**Consultation Response from KC,
Highways Development Management****2025/90778 land at, Albert Street Car Park, Albert Street, Lockwood, Huddersfield, HD1 3PR****Erection of two storey commercial unit****Date Responded: 26-8-2025.****Responding Officer: Mark Berry.****Responding Ref: 6-9NW-11.**

PROPOSED ELEVATIONS AND FLOOR PLANS	
ALBERT STREET CAR PARK, HUDDERSFIELD, HD1 3PR	
SCALE: 1:100 (ISO A2)	ALL DIMENSIONS IN MM
DATE: 19-03-25	PP/19325/2 Issue 1
PROPOSED SCHEME	2 OF 2

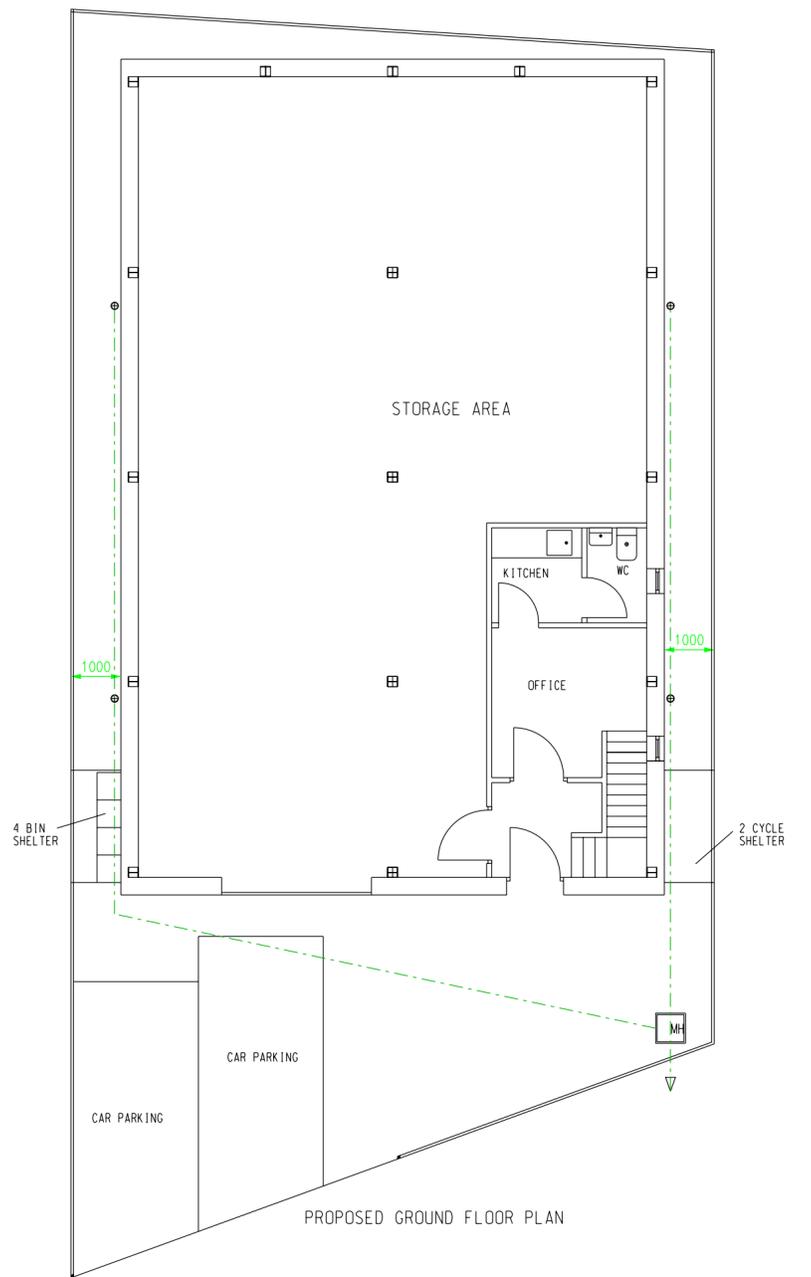
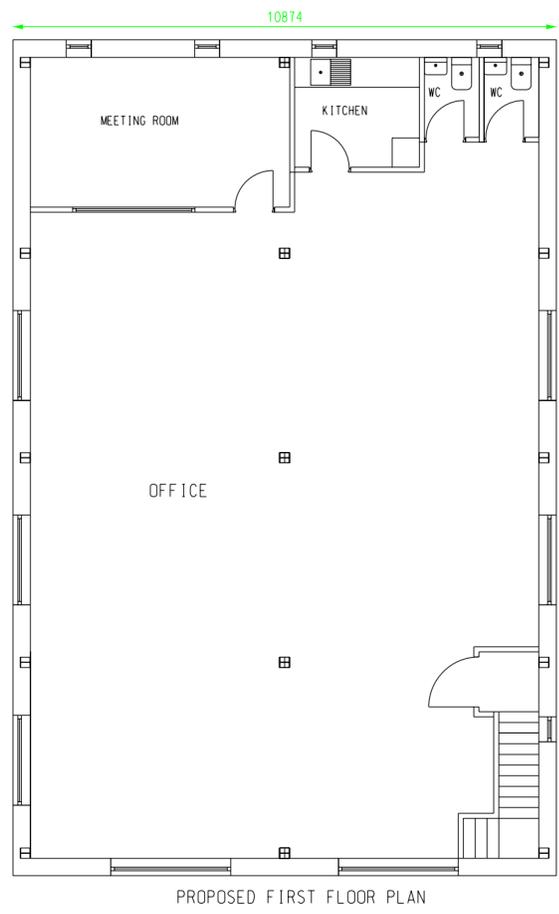
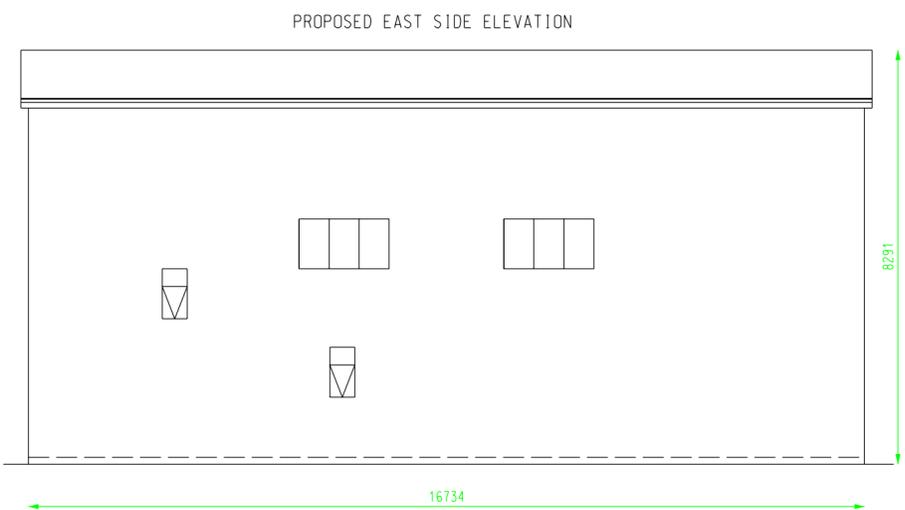
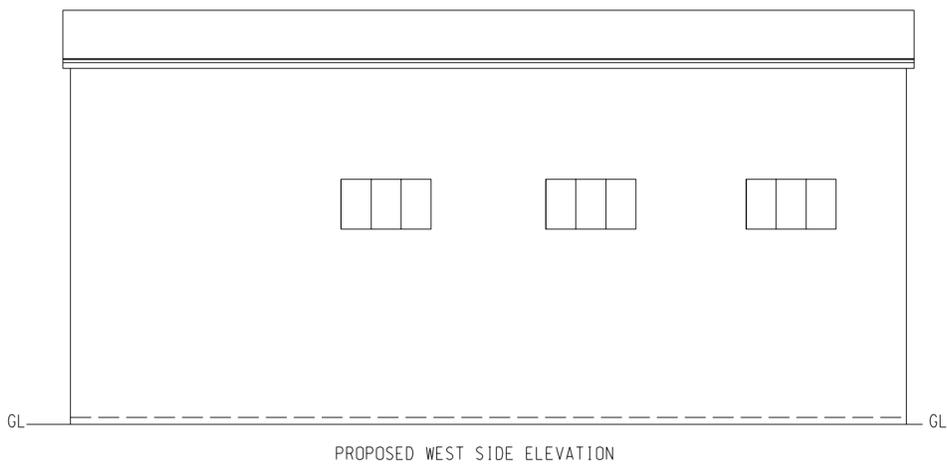
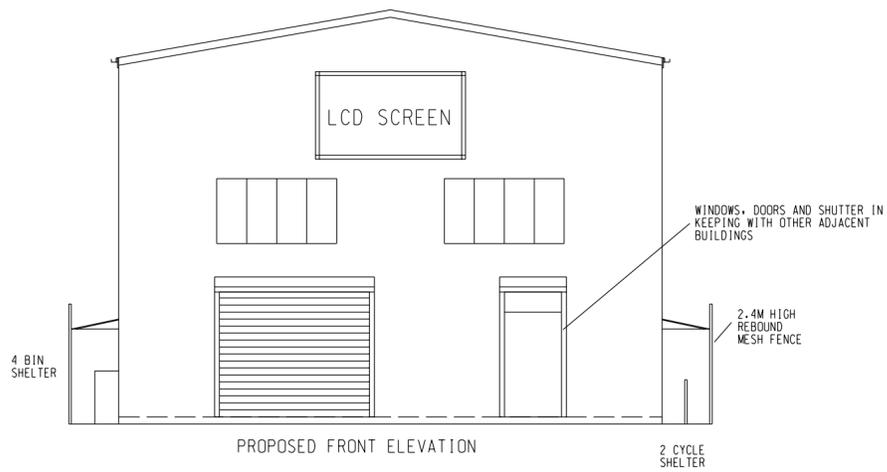
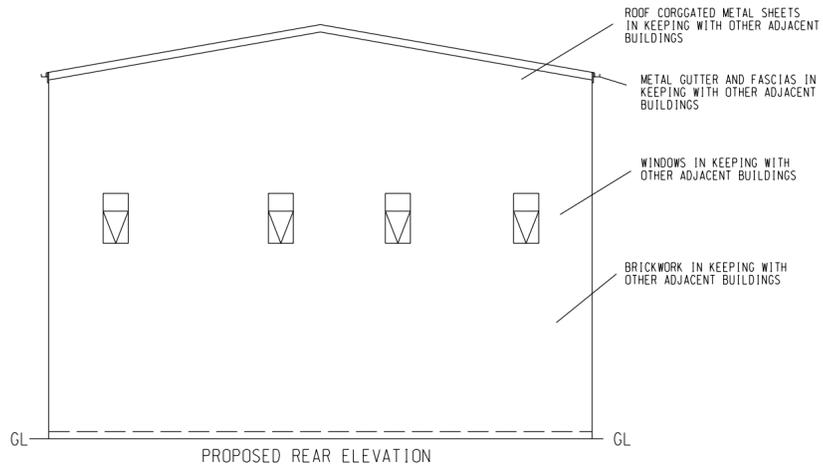
1, On-street parking in this area is generally at a premium and only 2 off-street parking space are proposed for two 163 sqm distribution and storage and office facilities. No internal vehicle turning facilities are proposed.

2, No information is provided regarding servicing of the proposed development. To be considered acceptable to H D M internal vehicle turning will need to be shown for the largest vehicle anticipated to service the site.

3, Vehicles should not need to reverse back onto or off Albert Street.

Given the above HDM are unable to support these proposals.
